Our Ref: AB/89/15/HH
Your Ref:

Town & Country Planning Act 1990 (as amended)
Town & country Planning (Development Management Procedure) (England) Order 2015
Application for Planning Permission for Works or Extension to a Dwelling

Development Rear single storey extension.

Location 29 Wood View Arundel

BLOCK PLAN 1:500

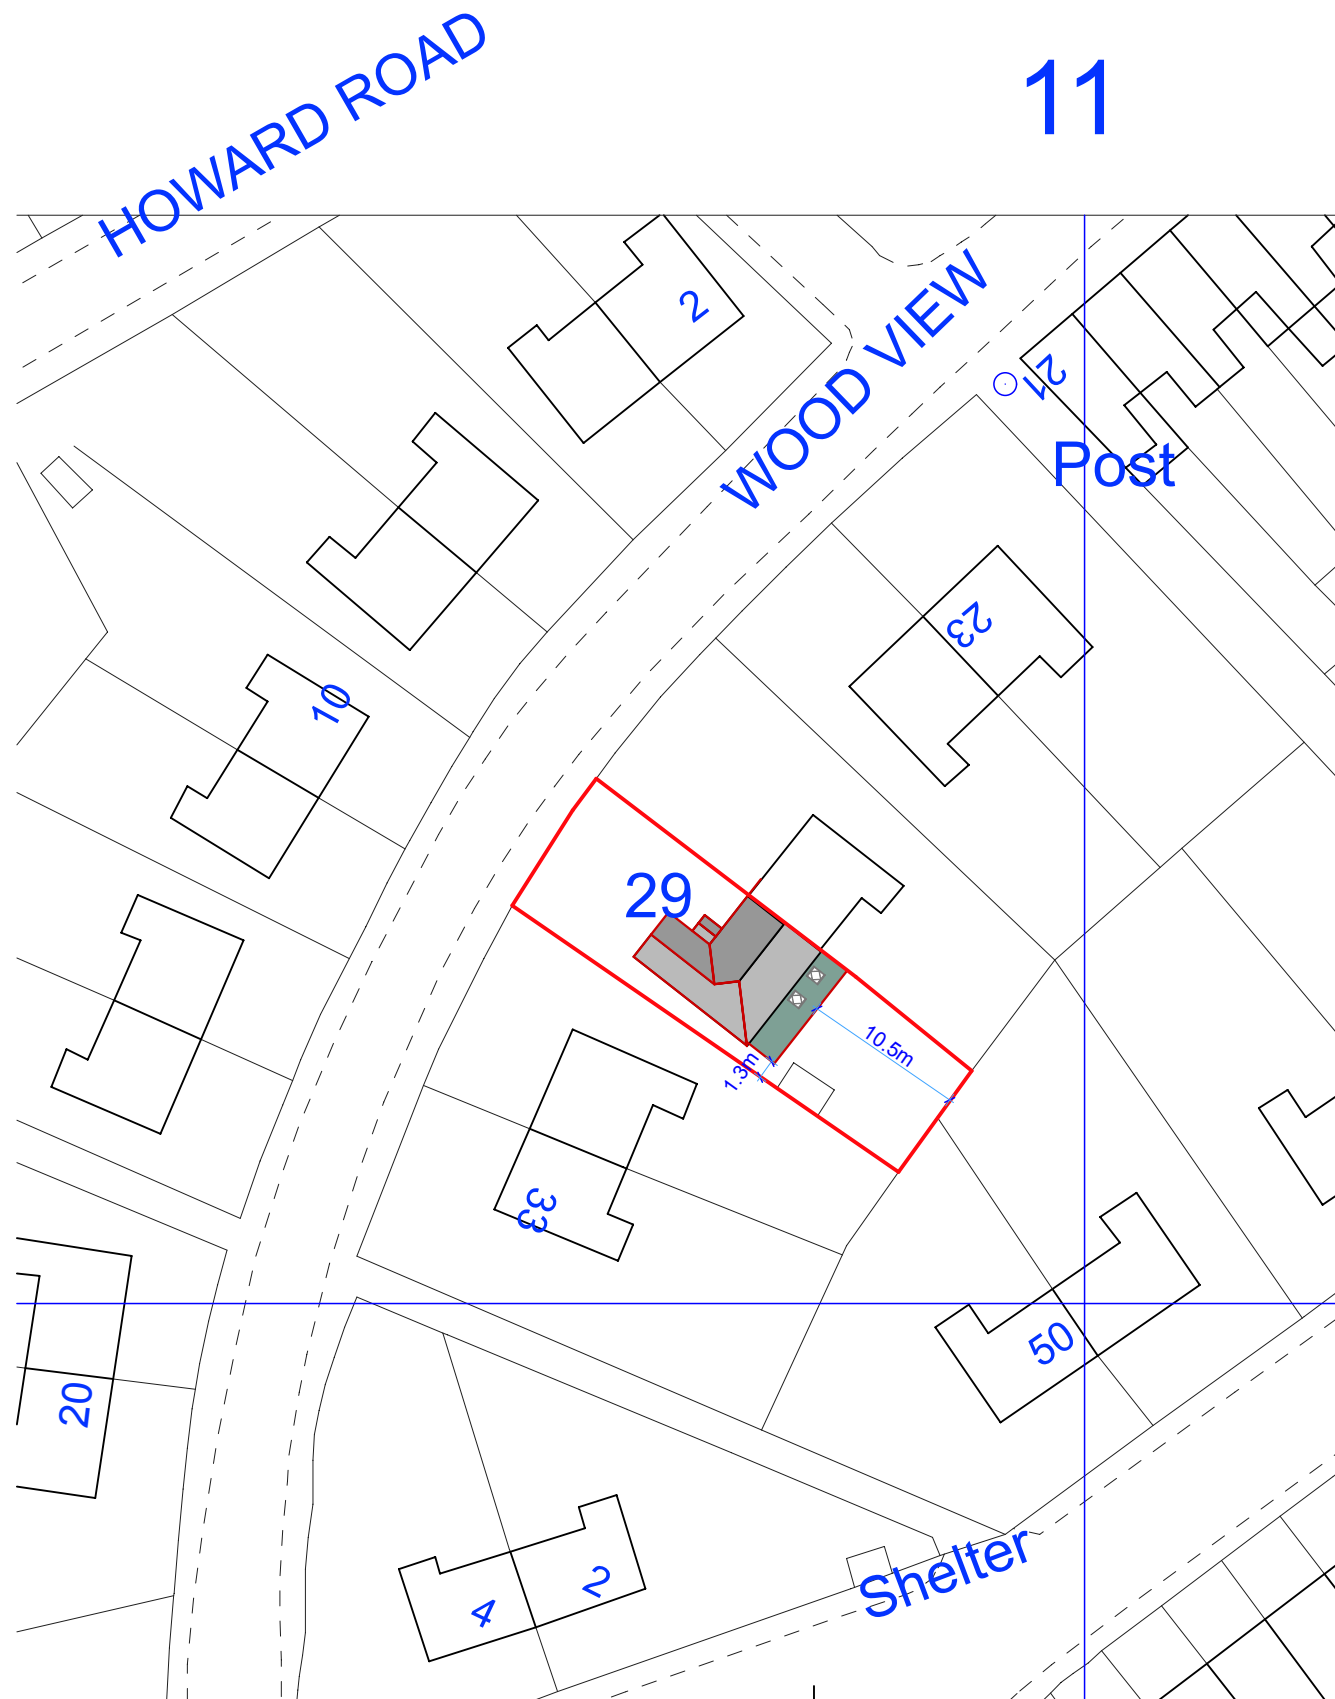
Please submit amended block plans showing the measurements to the boundaries

Drawing Name
Elevations- Existing

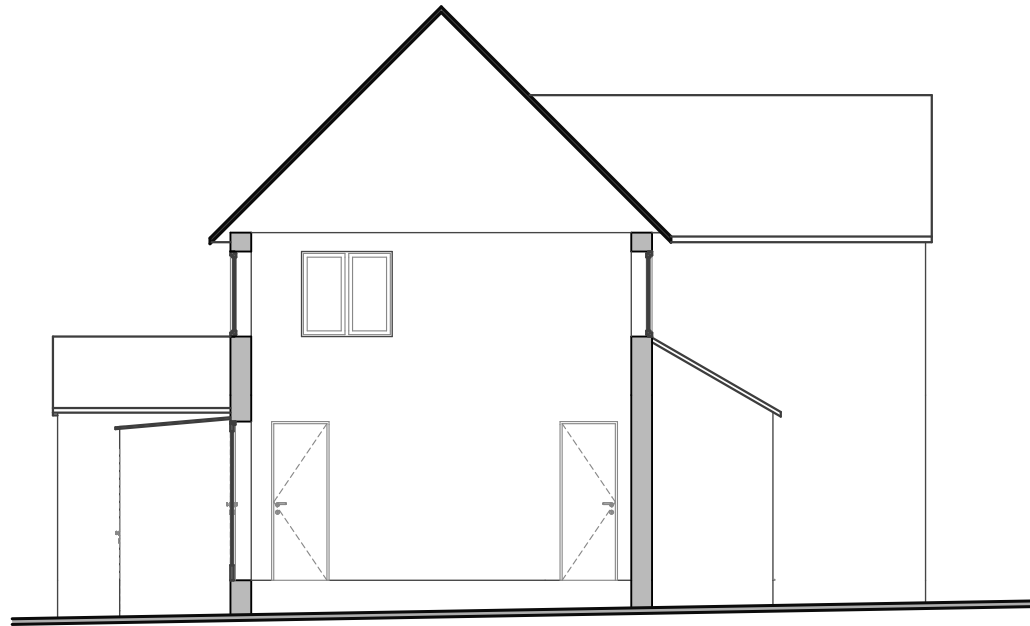
Please forward scaled existing elevations
